Memorandum

Re: **Harborview Townhouses; 121-129 York Street;
Harborview Development LLC, Applicant**

Project #: 2011-214 **CBL:** 44-A-4 and 5

Meeting Date: Planning Board Workshop April 26, 2011

DRAWING: MEZZANINE/THIRD FLOOR

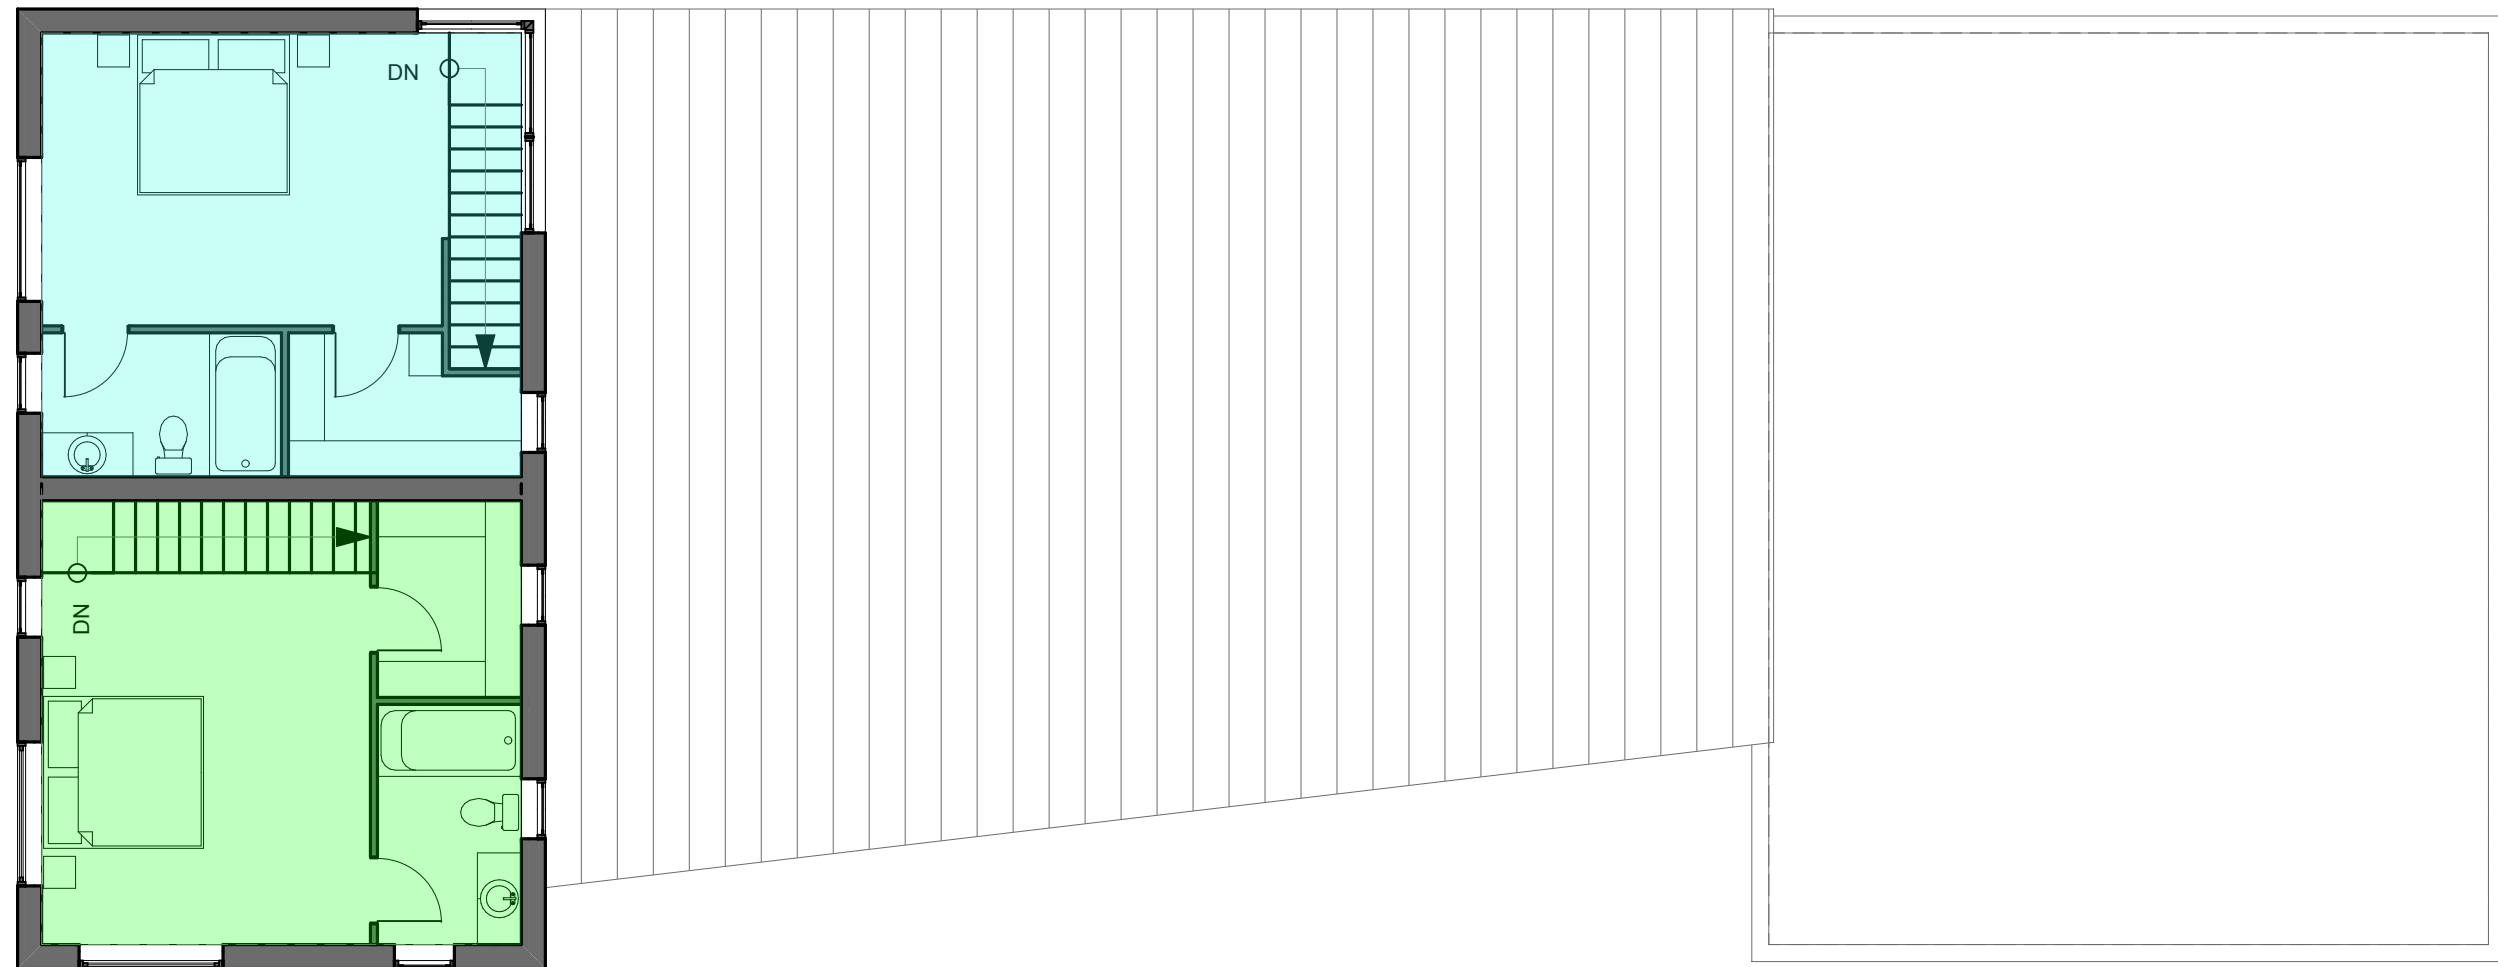
3. I am also in disagreement of how the applicant is using the terminology of a "mezzanine". This is a separate floor that is not associated with any other floor. There are fire walls from the front portion of this building. A mezzanine or loft is a reduce area level, above and within the same space of another.

This is another floor. It is a different level because of the grades on the property. At this point, I can only determine that the building is 4 stories and the required setbacks for the R-6 zone or 12' on each side are not being met.

DRAWING: SOUTHWEST ELEVATION

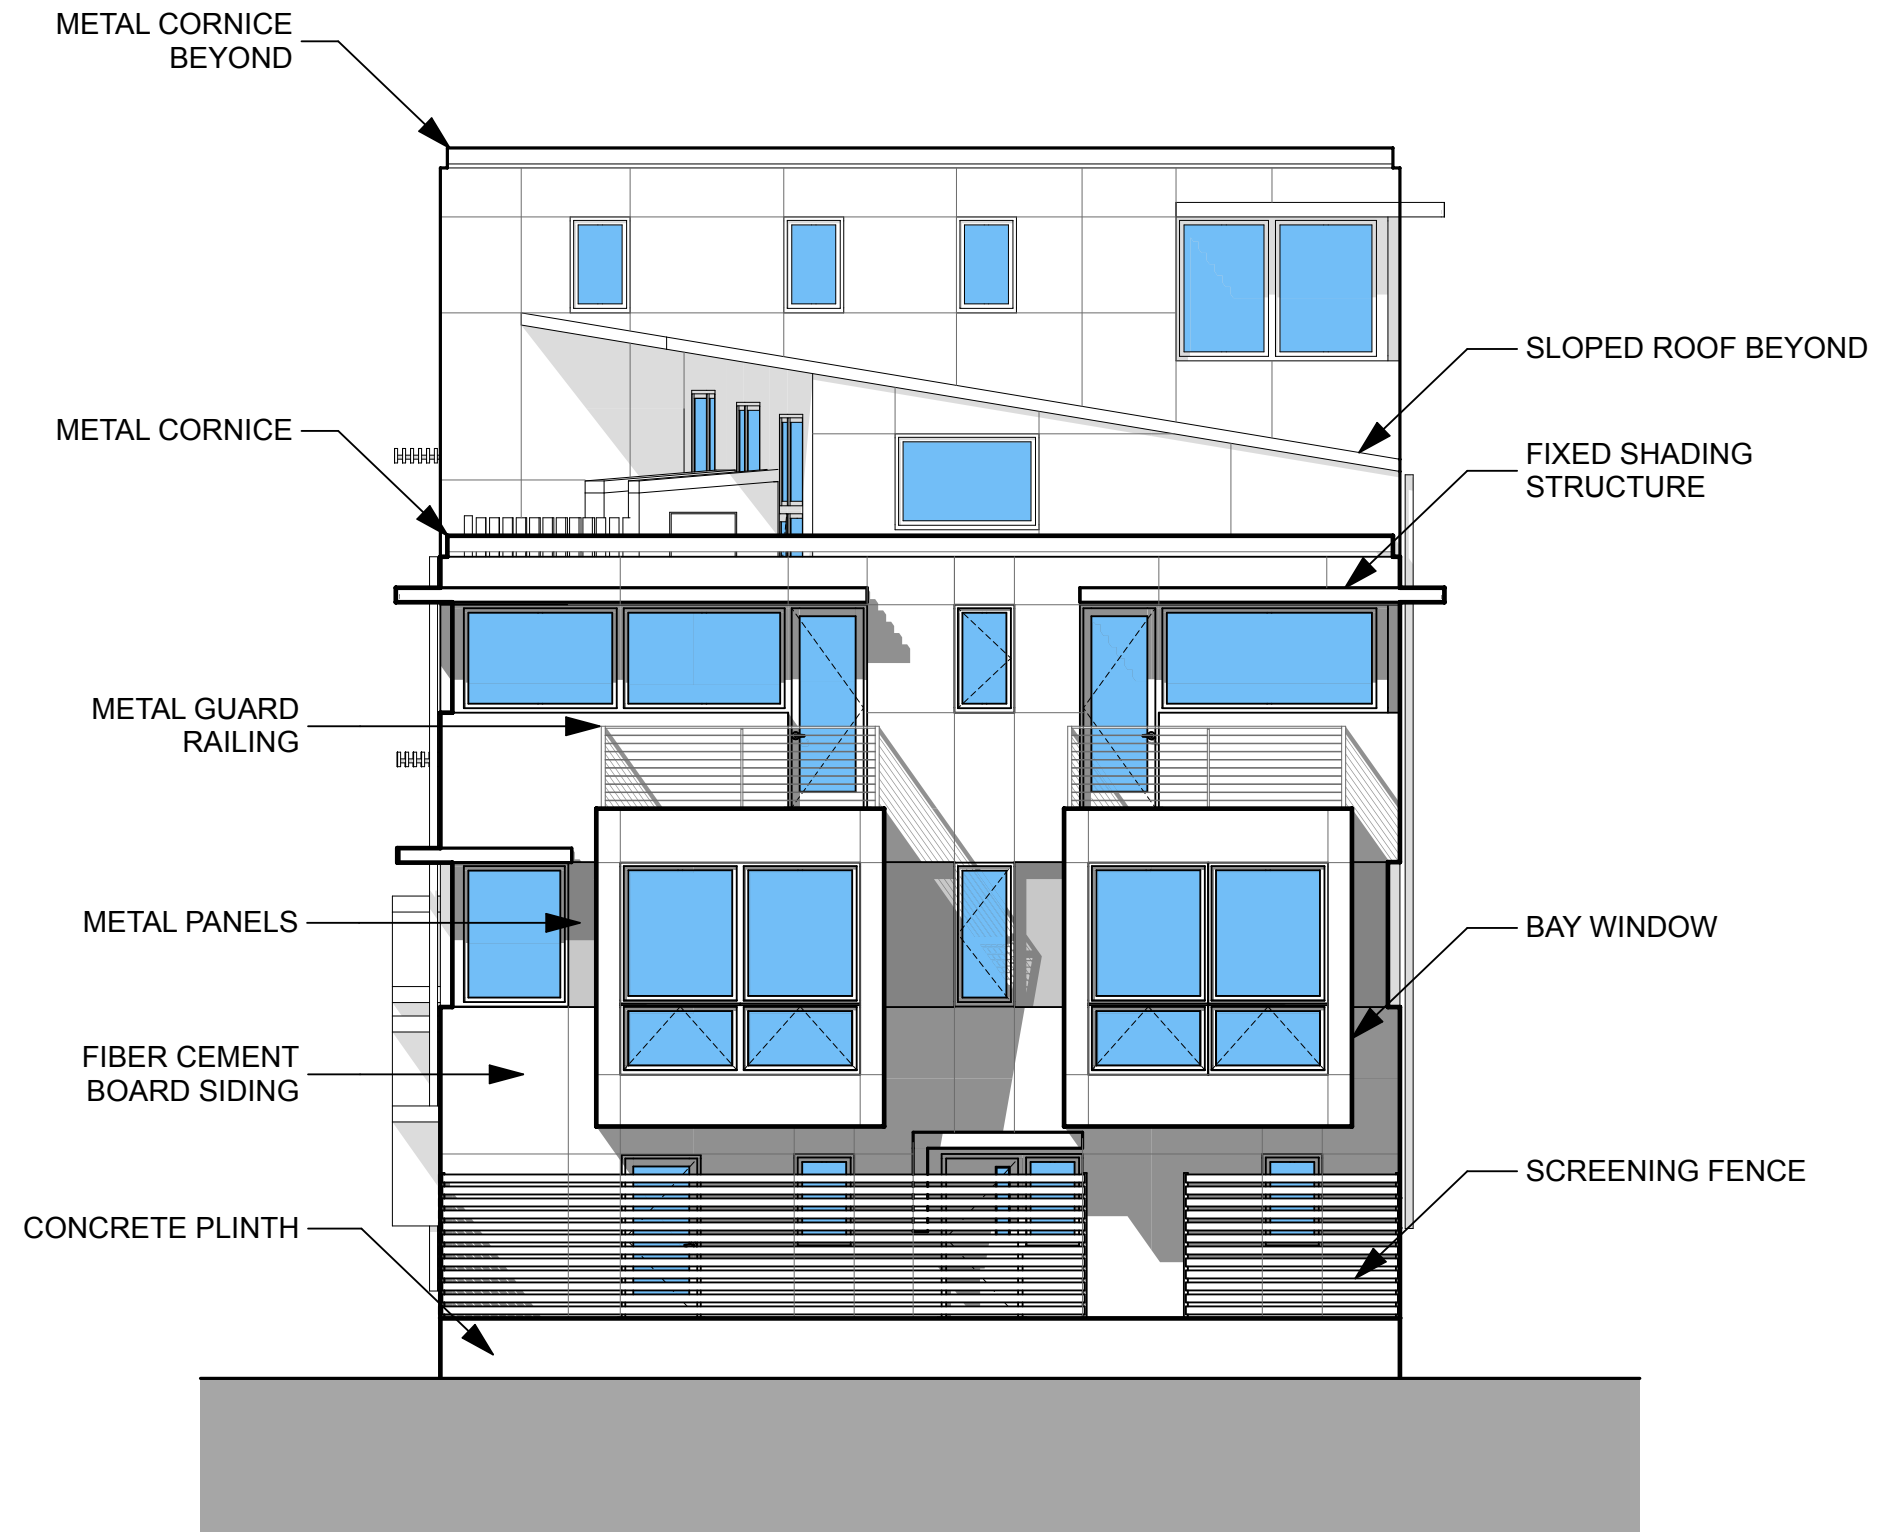
2. Thank you for the top of the highest roof beam elevation. However, when I do the math, the building is 6" higher than the maximum 45 feet allowed. ($97.39 - 51.89 = 45.5'$). The building is in violation of the maximum building height of 45'.
